**RESPONSE TO AGENCY ADVICE - SECTION 4.55(2) MODIFICATION APPLICATION (SSD-6957-Mod-1)  
CROWN SYDNEY HOTEL RESORT**

This letter has been prepared on behalf of the applicant, Crown Sydney Property Pty Ltd (**Crown**), in response to further correspondence received from the City of Sydney (**Council**) regarding a S4.55(2) Modification Application SSD-6957-Mod-1 (**Modification Application**) relating to the approved Crown Sydney Hotel Resort Development Consent SSD 6957 (**Development Consent**), located at 51a Hickson Road, Barangaroo, NSW.

Rev
01

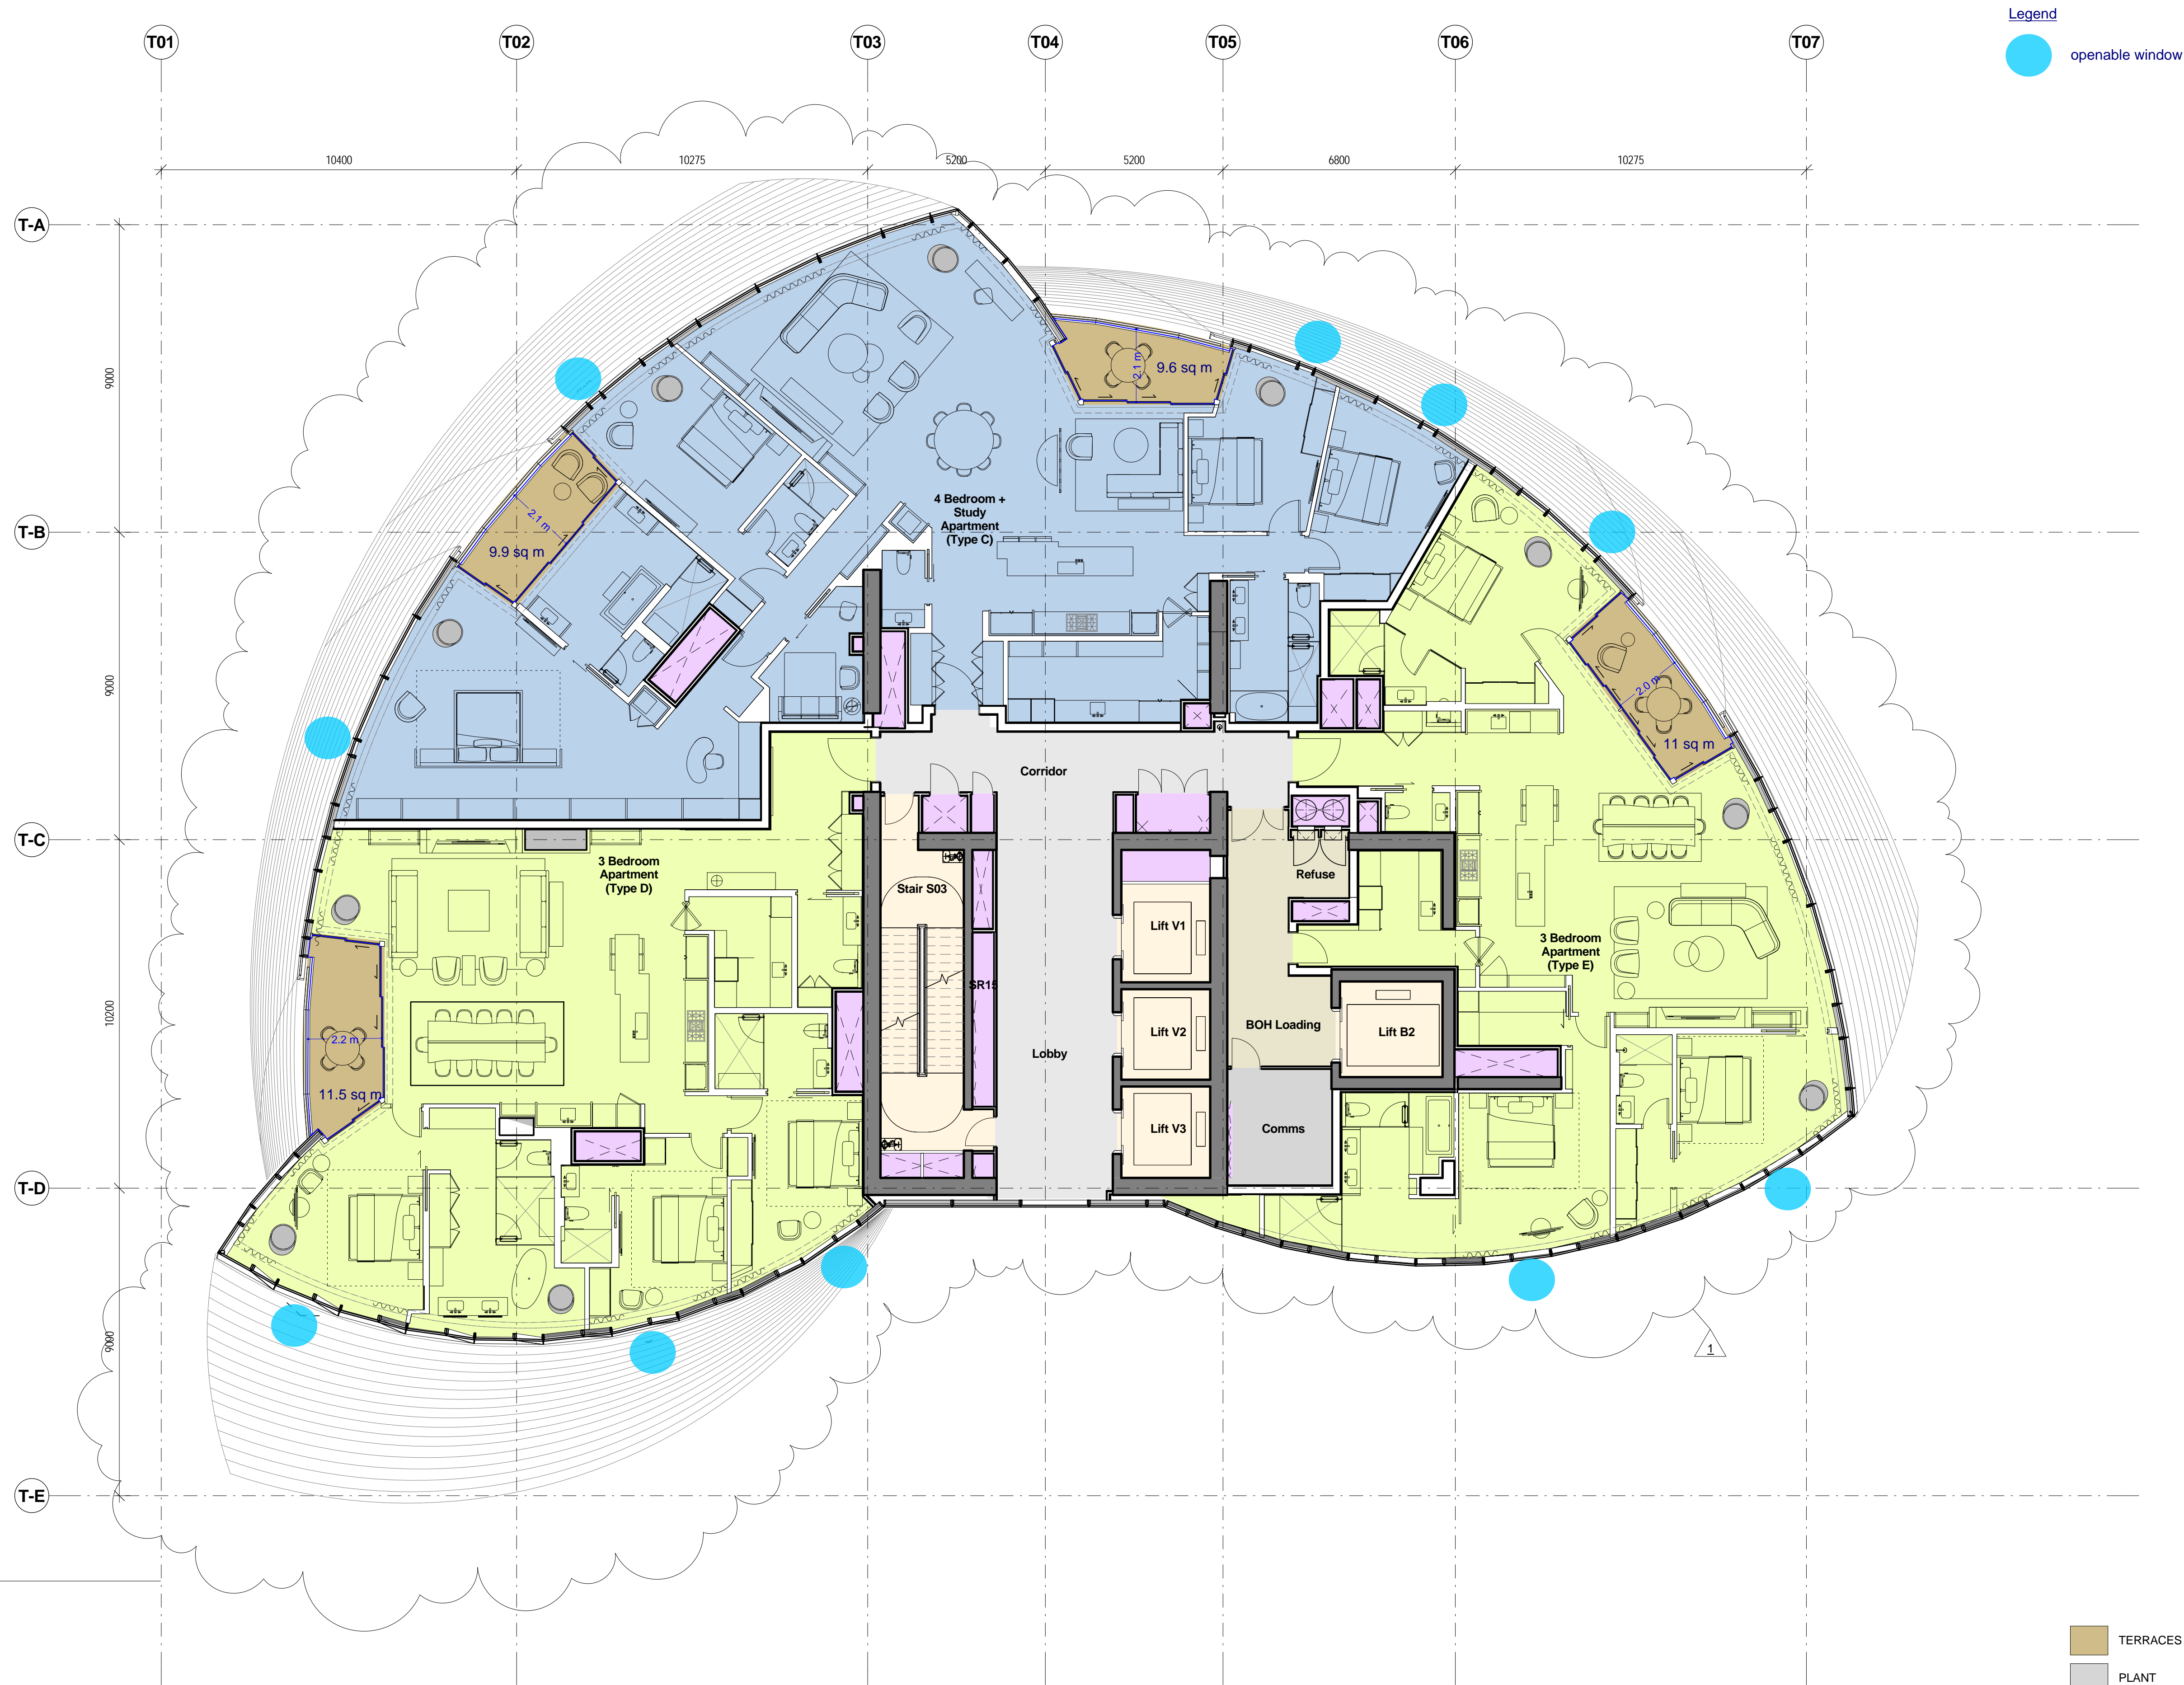
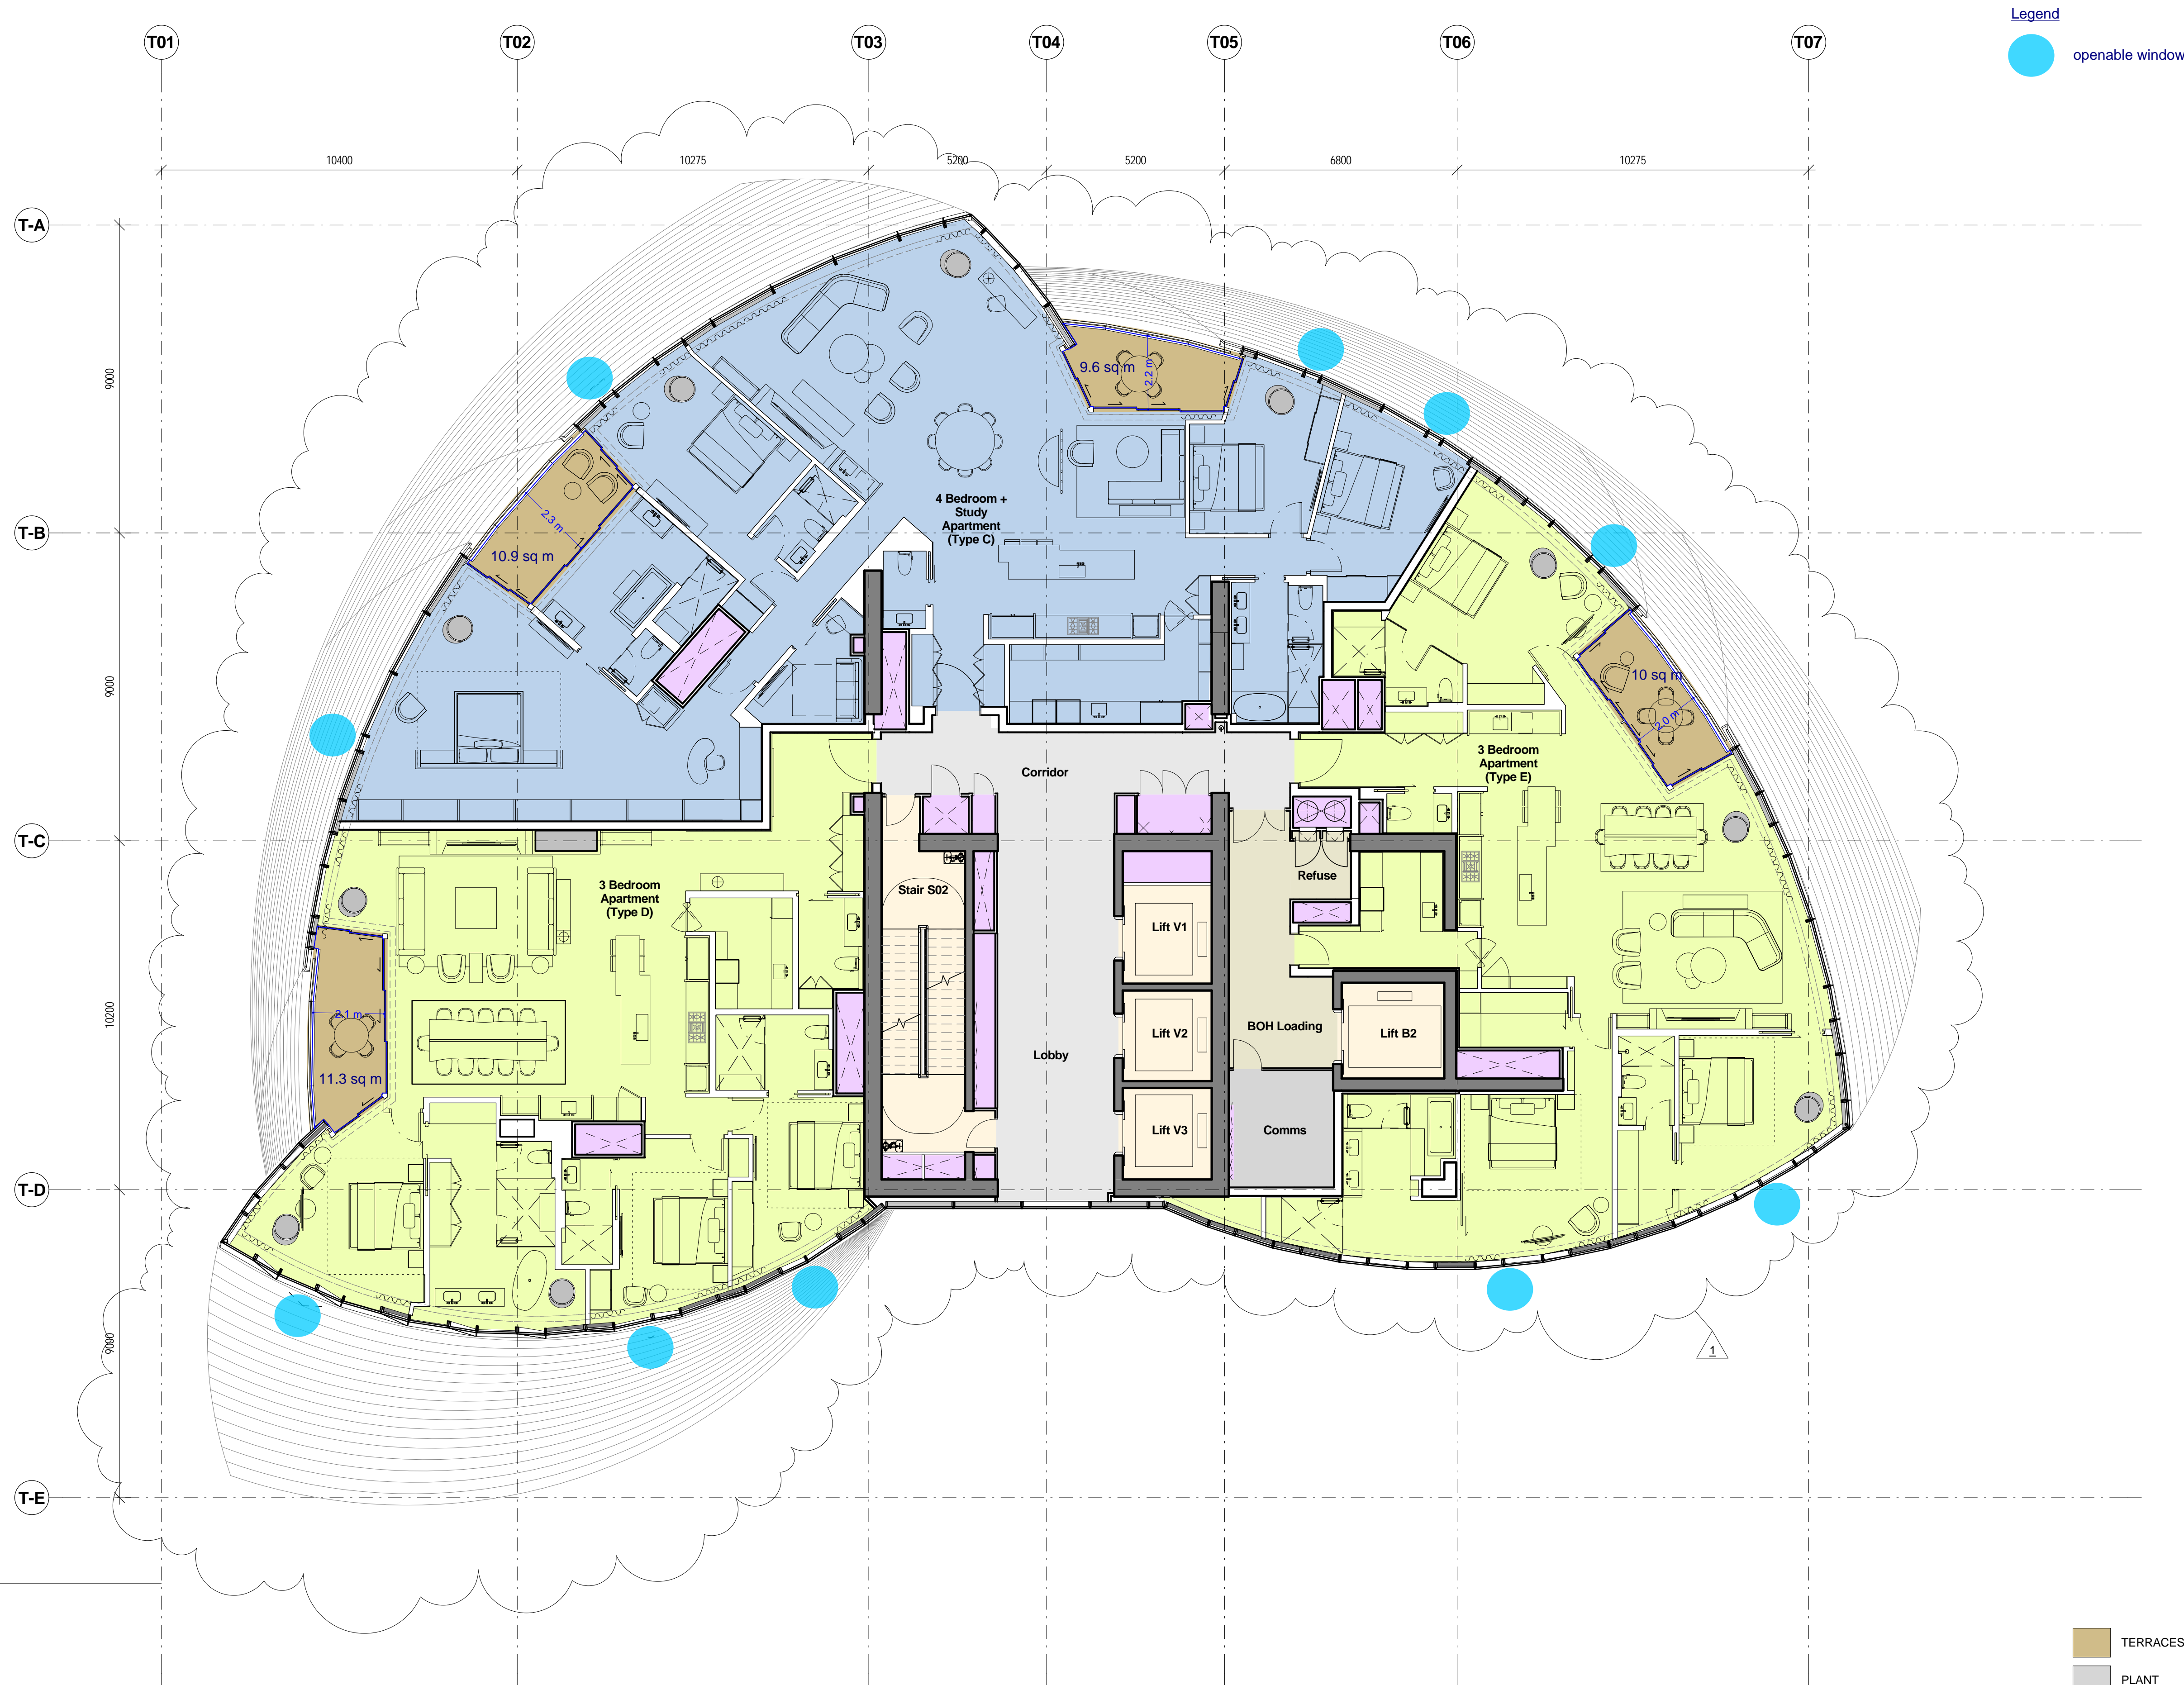
The ADG also states that to conform with the high wind balcony concession, *Natural ventilation also needs to be demonstrated*. The proposed design includes the provision of operable windows for natural ventilation to all apartments. These have been shown, for clarity, in **Attachment C**.

Figure 4E.2 Diagrams illustrating minimum balcony depth and options for noise treatment

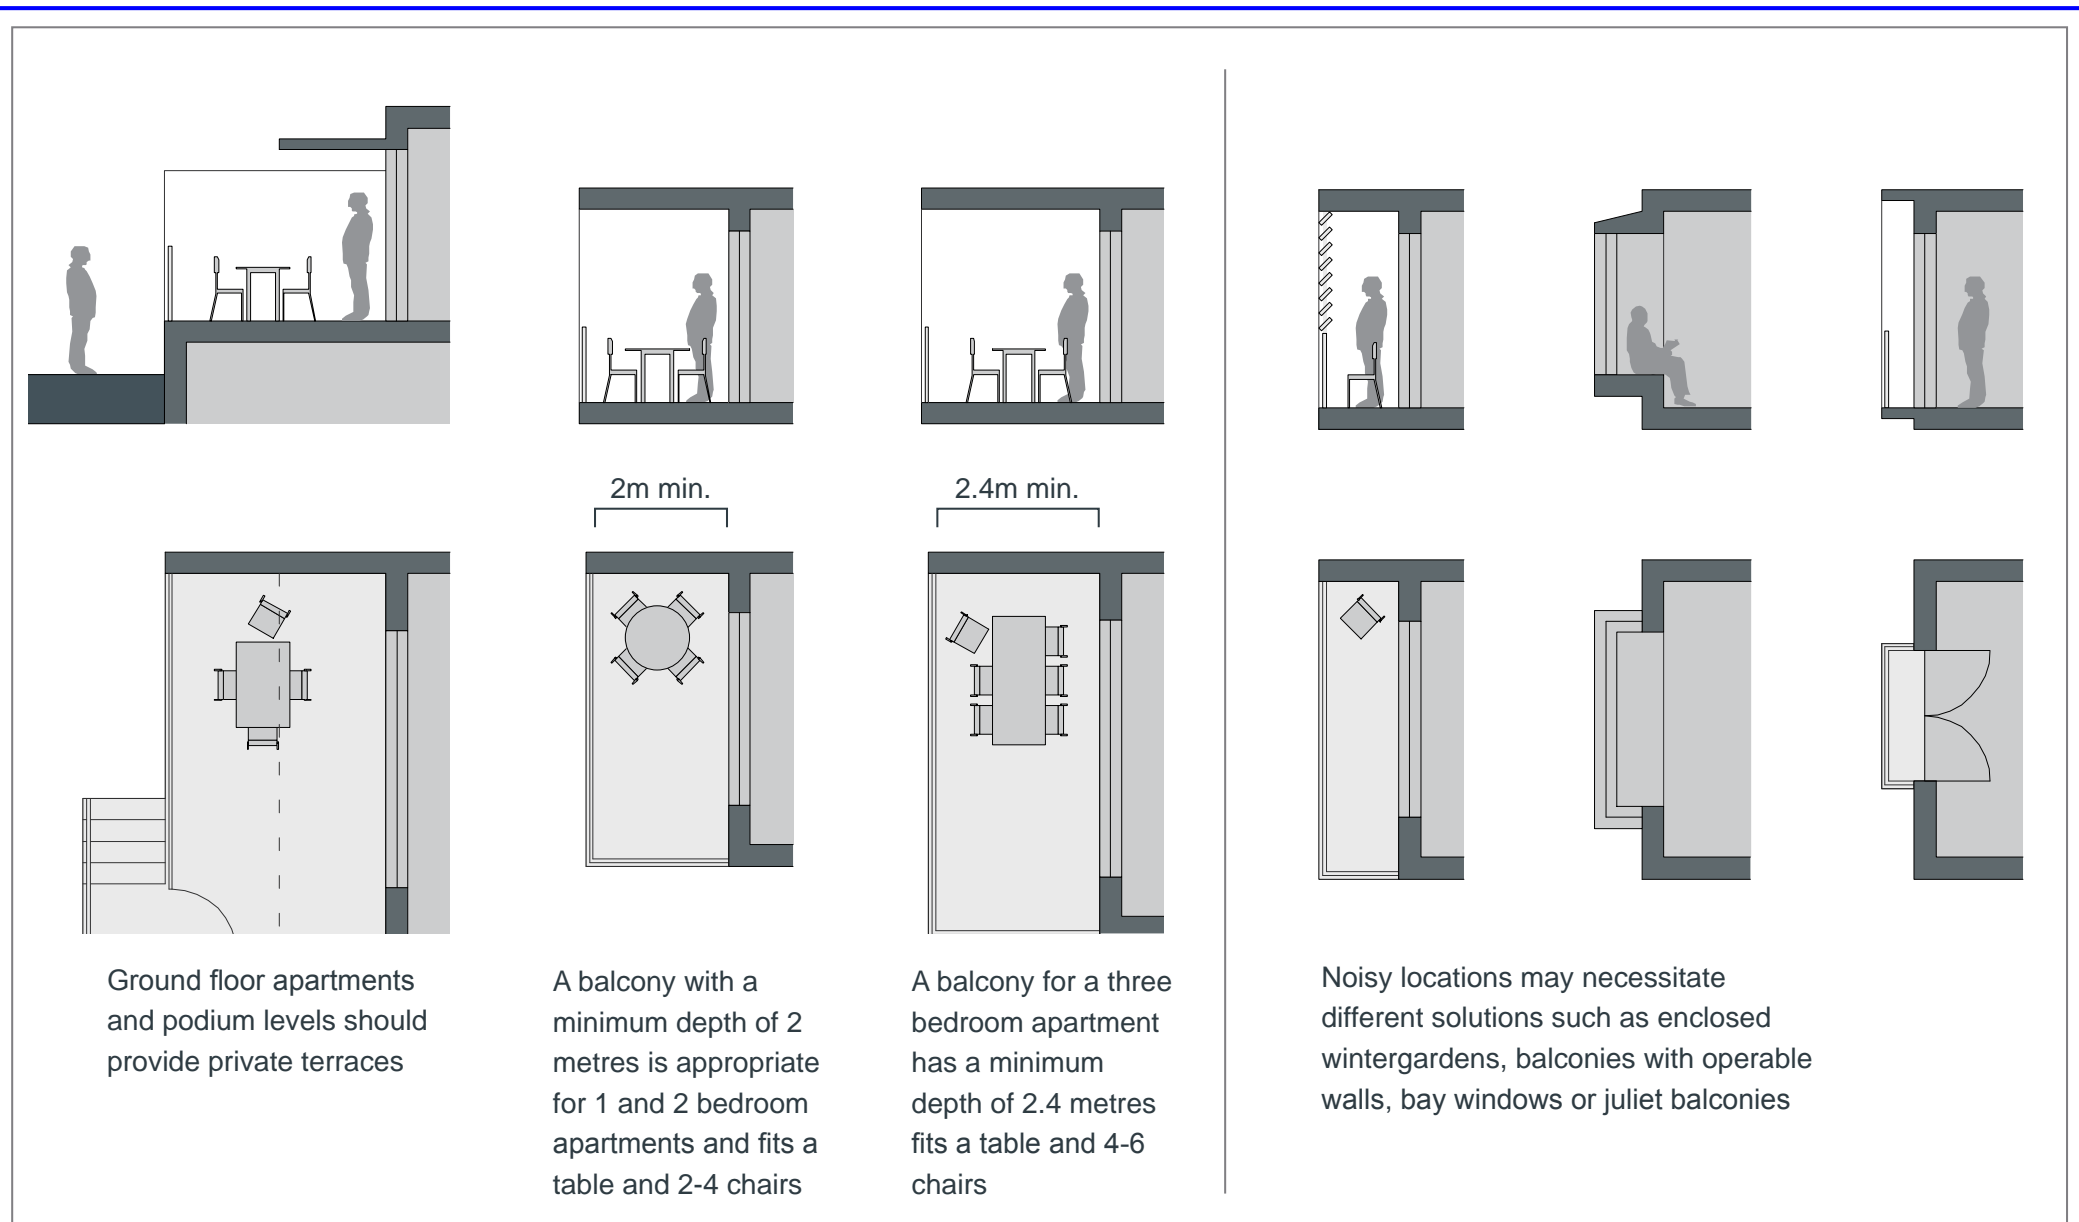
The ADG states that the use of balconies may be limited in situations where there are *consistently high wind speeds at 10 storeys and above*. The existence of consistently high winds has been confirmed by the RWDI Pedestrian Wind Study and all apartments are located from Level 33 to level 65, well above the 10 storey ADG benchmark. Limited use of balconies is therefore appropriate and consistent with the ADG in this case. The ADG further explains that *in these situations, juliet balconies, operable walls, enclosed wintergardens or bay windows may be appropriate, and other amenity benefits for occupants should also be provided in the apartments or in the development or both*. The proposed design solution limits the number of fully open balconies and incorporates juliet balconies and operable walls, both of which represent a design solution that is entirely consistent with the ADG. The location of the juliet balconies have been shown in **Attachment C** and will be to be consistent with the diagram on page 92 of the ADG, Figure 4E.2 (See juliet balcony detail at **Attachment D**).
